Sioned Vos
Chairman, East Preston & Kingston Preservation Society
17 Vicarage Lane, East Preston
Littlehampton
West Sussex
BN16 2SP

Application No: EP/33/25/PL
Site Address: Seafield Lodge Seafield Road East Preston BN16 1NA
Description of works: Demolition of existing dwelling and construction of 1 No. new dwelling (self/custom build). This application is in CIL Zone 4 and is CIL Liable as a new dwelling.

Thank you for your internet representation made on 9th May 2025 which has been recorded as an objection with the comments as follows:

Drawing Name  
Elevations -  
Proposed

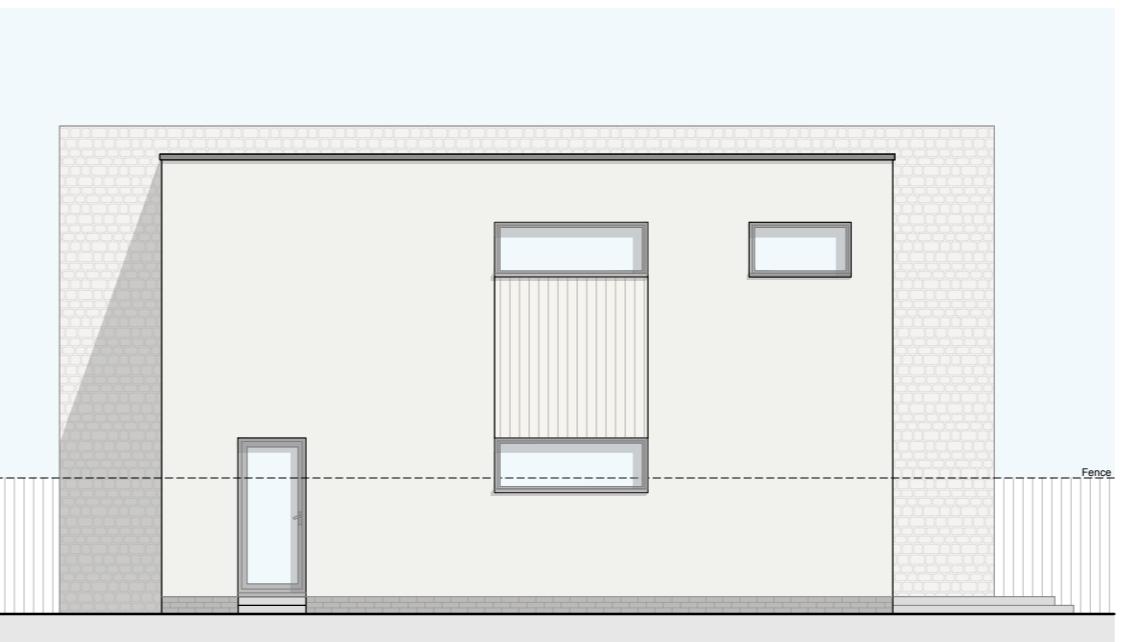
We regret the fact that the applicant is not pursuing a more traditional house design, as agreed for the previous application on this site, which would have fitted in with the neighbouring properties. The design proposed would not integrate as well, being overly cuboid and blocky in appearance, though we appreciate that efforts have been made to relieve a mundane geometry.

It is, as acknowledged, crucial that the boundary wall along Sea Road and curving towards Seafield Road is retained. It is also important that the materials used in any approved design harmonise with others in the area. With this modern design, perhaps a slightly darker cream and more golden oak palette than that which is applied for, might provide a better transition between the two different styles of house in this AoC.
